**re: Grading and Site Servicing Review**  
**Proposed Industrial Development**  
**6160 Thunder Road, Ottawa, Ontario**

**date: August 12, 2024**

**file: PG5161-MEMO.04 Revision 1**

## **2.0 Grading Plan Review**

DRAWING TITLE: GRADING AND DRAINAGE - OVERALL PLAN

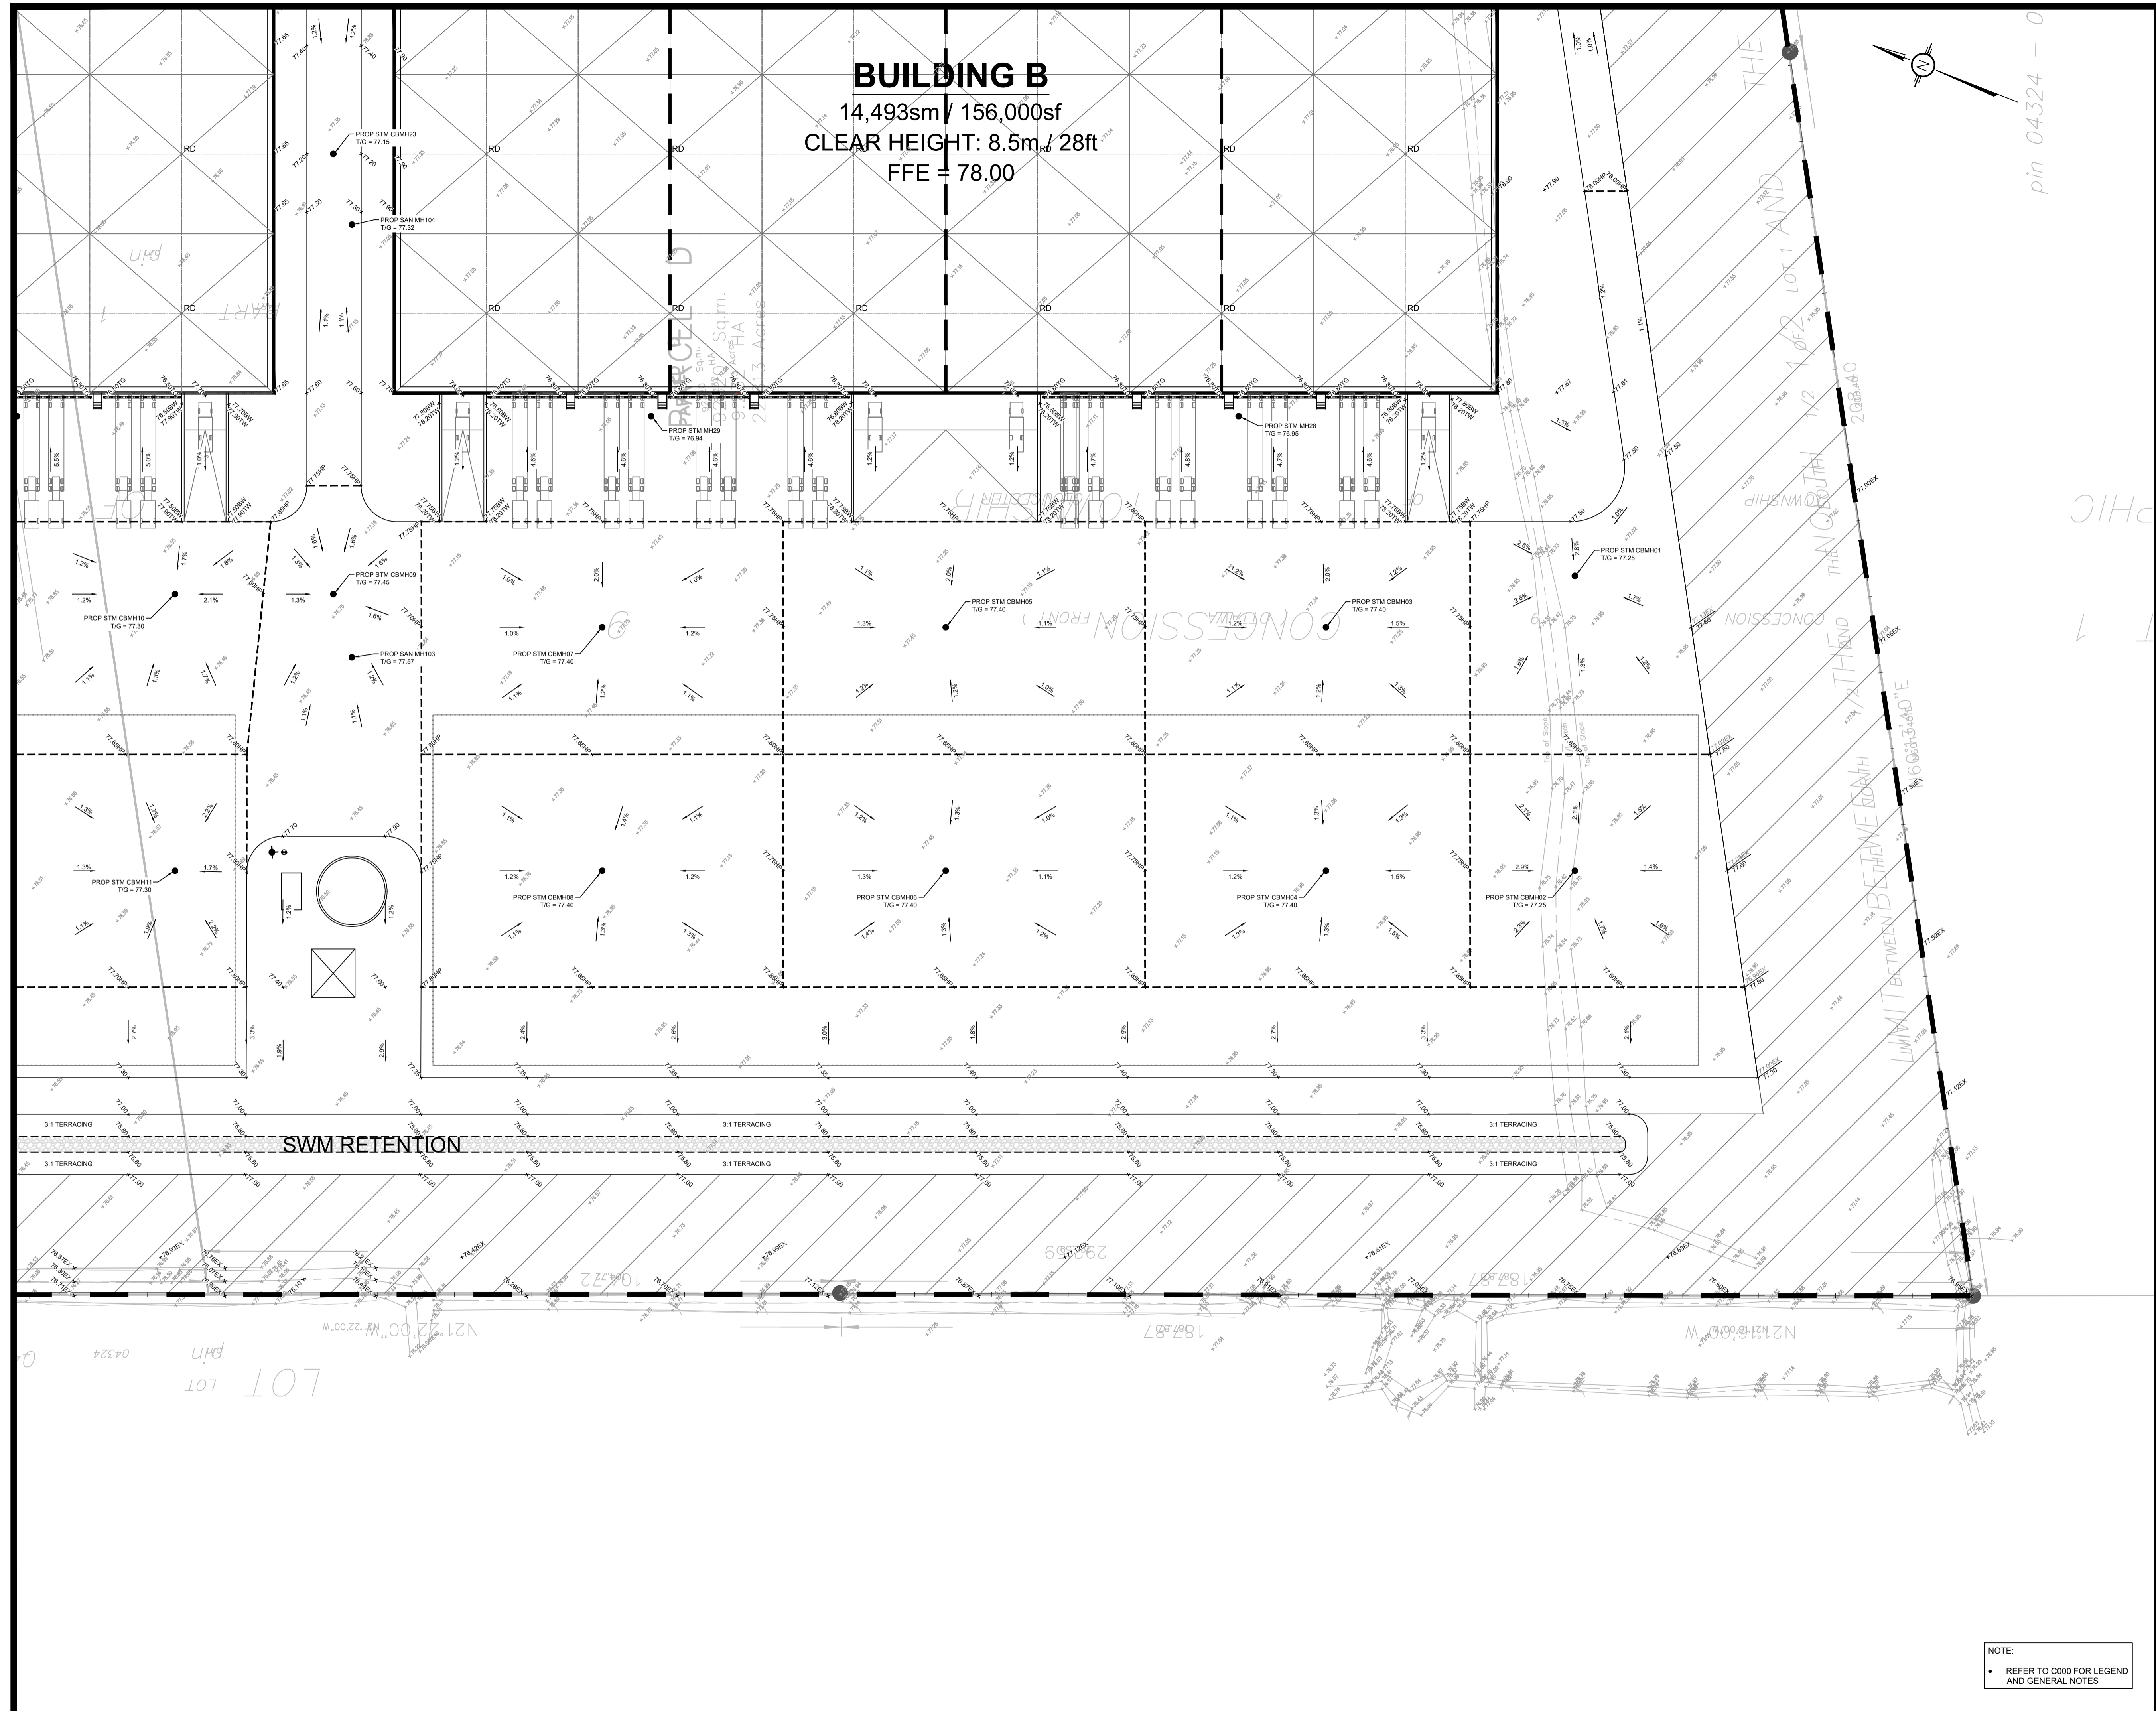
Based on our review of the above-noted drawing, the proposed grading for the Industrial building and the VIC Structure exceeds the permissible grade raise recommendations provided in the geotechnical report. Our grading summary and lightweight fill recommendations are presented in Table 1 – Soil Matrix Summary attached.

Around the buildings, the LWF EPS blocks should be a minimum of 1 m thick and extend a minimum of 2.4 m outside the foundation walls. Between 2.4 to 4.8 m outside the foundation walls, a minimum of 0.6 m thick EPS LWF blocks should be installed. And between 4.8 to 6 m outside the foundation walls, a minimum of 0.3 m thick EPS LWF blocks should be installed. Refer to Figure 1 attached to the end of the memorandum for detailed drawings.

Below the pavement and landscaped areas, the LWF EPS blocks should be comprised of EPS 19 and EPS 15 blocks respectively and should be placed as per the marked-up site plan attached to the end of this memorandum.

Due to the smaller permissible grade raise exceedance in the paved an storage area, a settlement surcharge program can also be conducted within the noted areas in light green (refer to attached mark-up) on the attached site plan. It is recommended to pre-grade the proposed parking and storage areas with approved fill and surcharge the area to a minimum of 0.6 m over the proposed final grade, over an anticipated period of six (6) to eight (8) months. Paterson shall monitor the settlement of the ground to confirm settlement rates and completion of the surcharge program. The completion of a successful surcharge program would eliminate the need for LWF within these areas.

The LWF EPS blocks should be comprised of EPS 19 under the slab on grade structures below office spaces. The LWF blocks should be comprised of EPS 22 under the slab on grade below the VC structure and EPS 29 should be used under the slab on grade where heavy equipment may travel (Garage).

- All the EPS LWF blocks should be covered with a polyethylene sheet and surrounded with a non-woven geotextile such as Terrafix 270R.
- Within and around the buildings, the LWF should be placed against the foundation wall, above the footing, and a minimum of 300 mm below the finish surface or 400 mm below the slab on grade.
- The Lightweight Fill material backfill material should consist of EPS 19 under pavement and parking structures and EPS 12 around the remainder of the foundation under landscaped area.
- Within the slab on grade structures, the 400 mm fill layer on top of the LWF can consist of OPSS Granular A.
- Within landscaped areas, the 300 mm fill layer on top of the LWF can consist of in-situ fill material covered with a minimum of 100 of topsoil.
- Within the pavement areas, the 300 mm fill layer on top of the LWF can consist of OPSS Granular A or Granular B type II.

DRAWING TITLE
 SERVICING - OVERALL PLAN

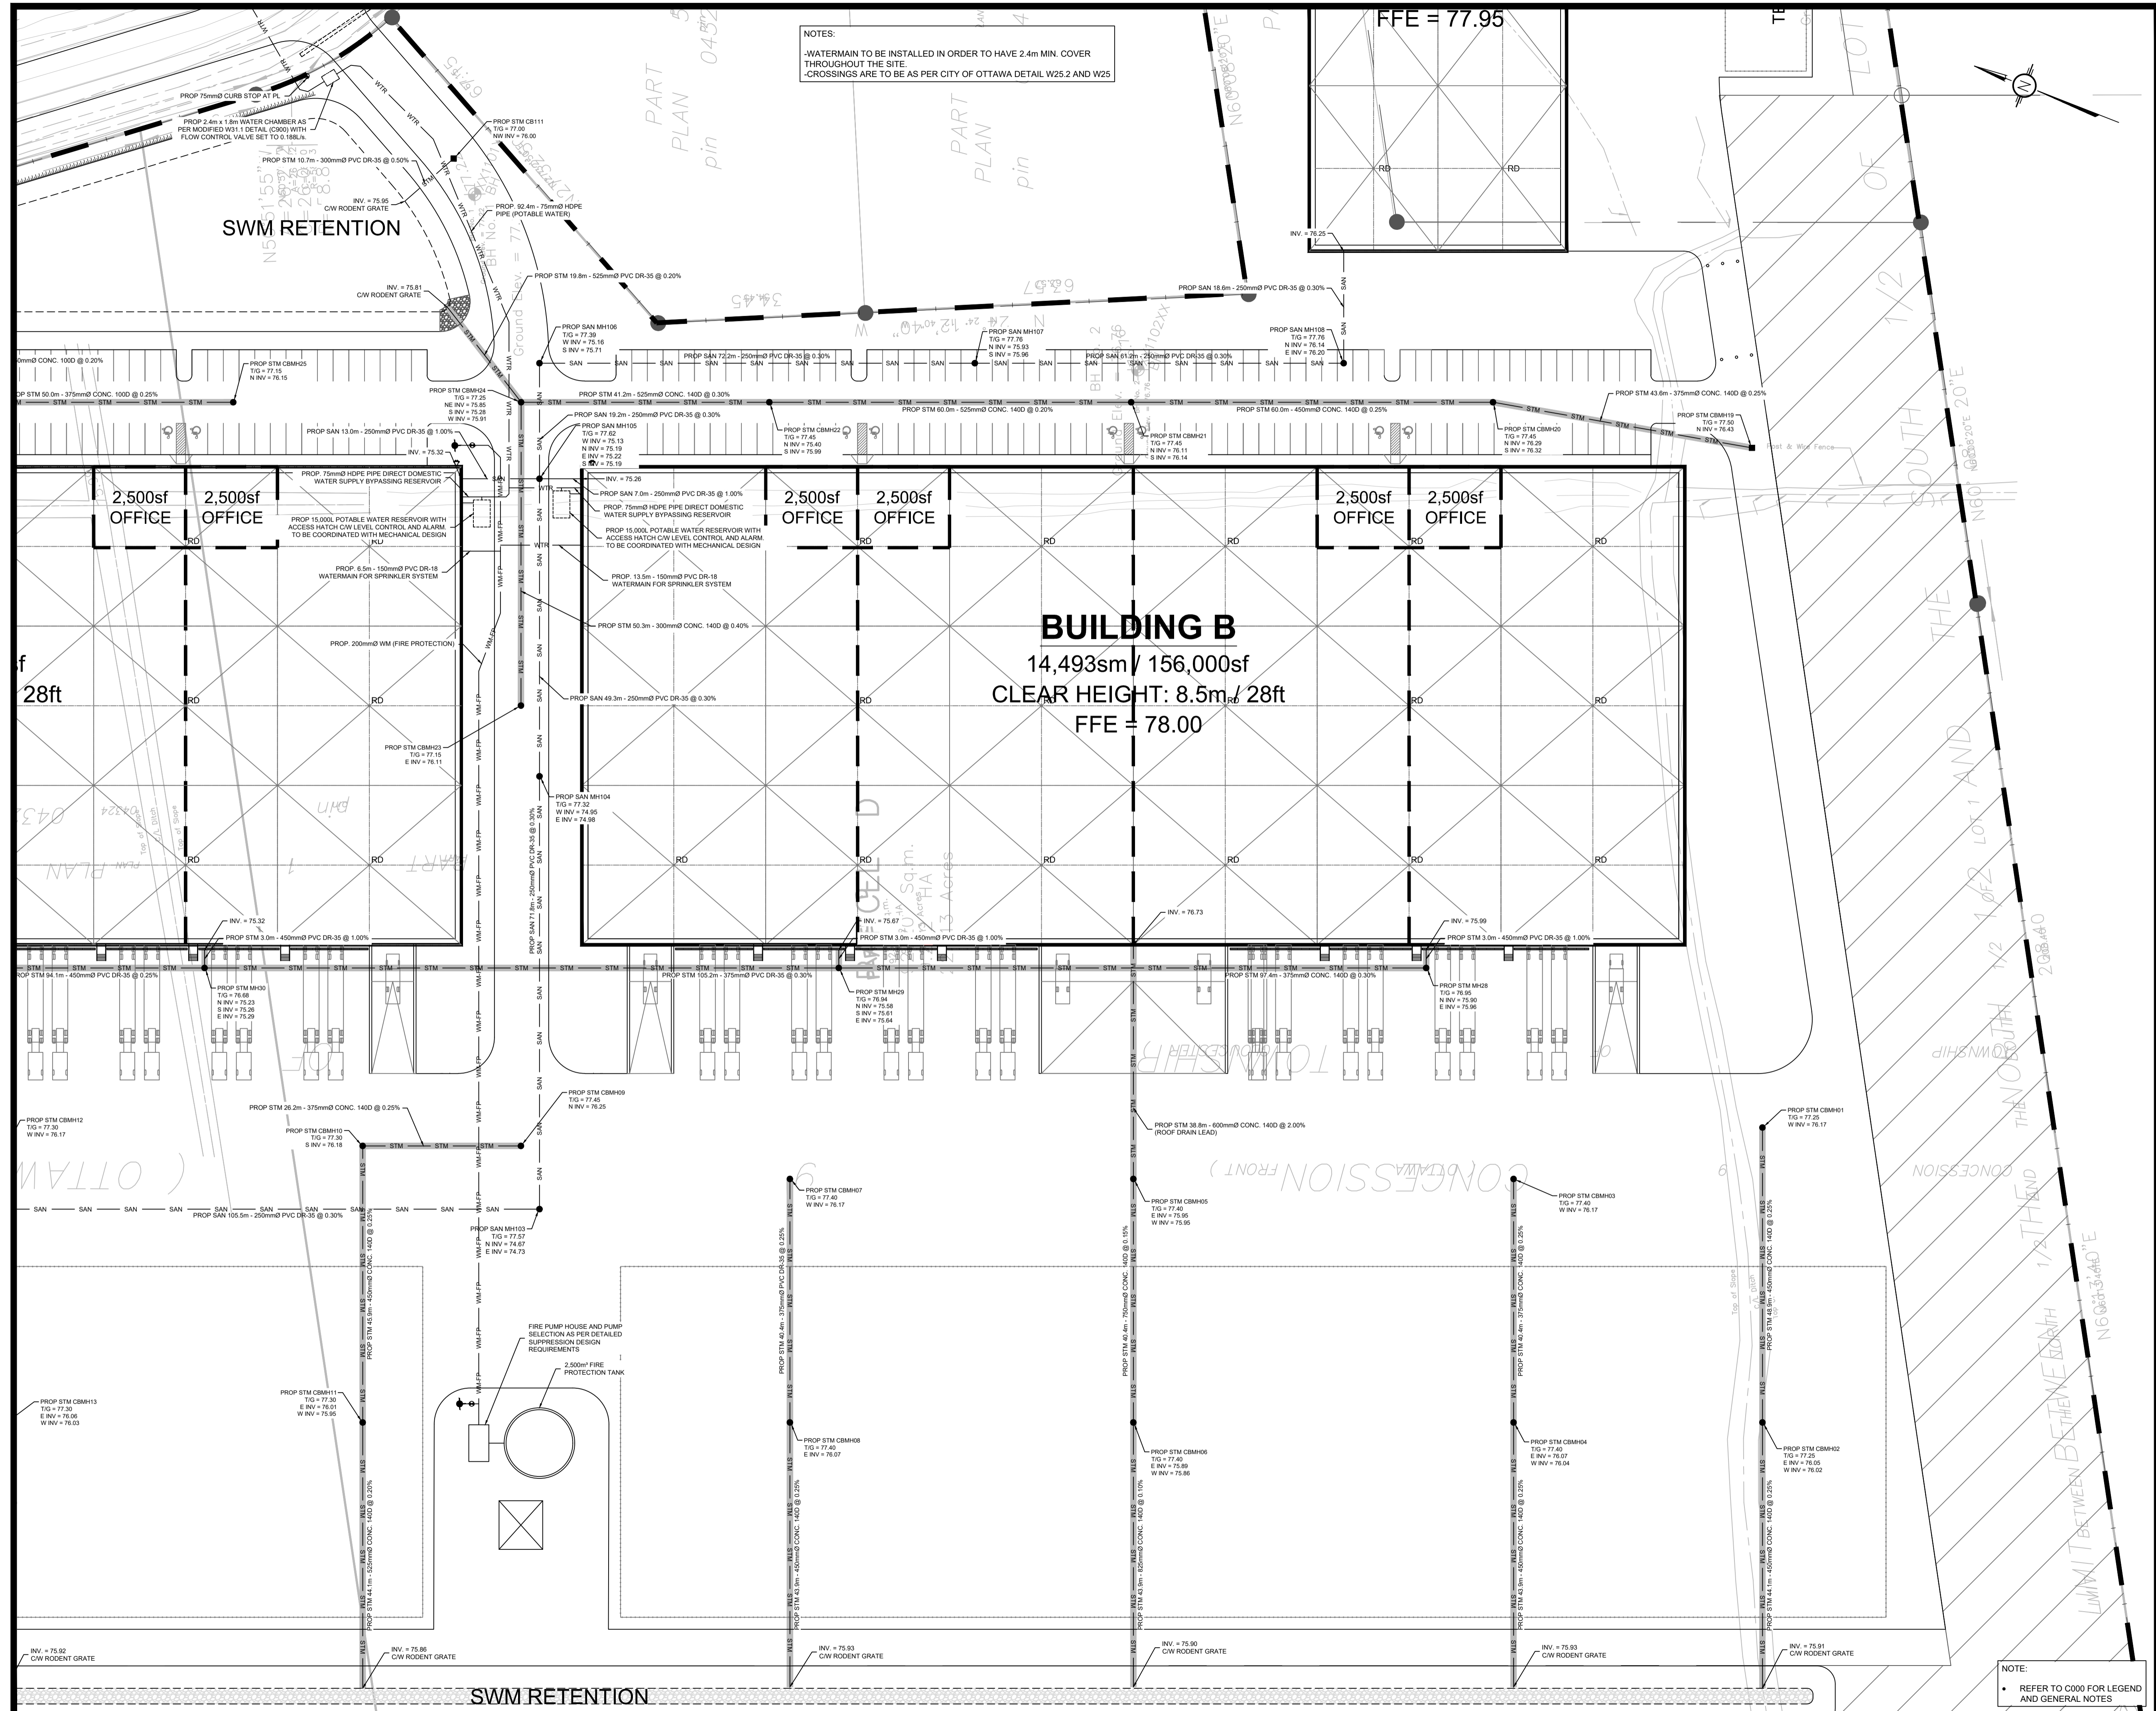
In the gravel storage area, it is expected that approximately 25 to 50 mm of settlement can be expected over time. Therefore, the to maintain minimum drainage slope along the servicing lines some catchbasins will require LWF. A minimum of 0.6 m of EPS 19 extending 1.2 m around the catchbasin should be used to protect the structures as indicated on the attached plan.

Based on our review of the Site Servicing Plans, it was noted that some portions of the proposed storm service lines will have less than 2.1 m of soil cover above the invert elevation of the pipes. Where insufficient soil cover (i.e.- less than 2.0 m) is available, the following frost protection criteria outlined in Table 1 below.

Table 1: Frost Protection Recommendations		
Soil Cover Provided D (mm)	Insulation Dimensions (mm)	
	Thickness (mm)	Length (mm)
1,100 to 1,400	75	Extend 900 mm horizontally beyond the edge face of the pipe
1,400 to 1,700	50	Extend 600 mm horizontally beyond the edge face of the pipe
1,700 to 2,000	50	Extend 300 mm horizontally beyond the edge face of the pipe

The rigid insulation should be placed 150 mm above the pipe on top of a compacted Granular A backfill and should have a minimum of 150 mm of Granular A backfill above the rigid insulation. Rigid insulation placed underneath roadways less than 1.2 m from the surface should consist of high density extruded polystyrene HI-40 or better. The insulsation should be coordinated with the proposed LWF insulation under pavement areas. Any portion of the storm service pipe installed at a depth of 2.0 m below finished grade or deeper is considered acceptable from a geotechnical perspective.
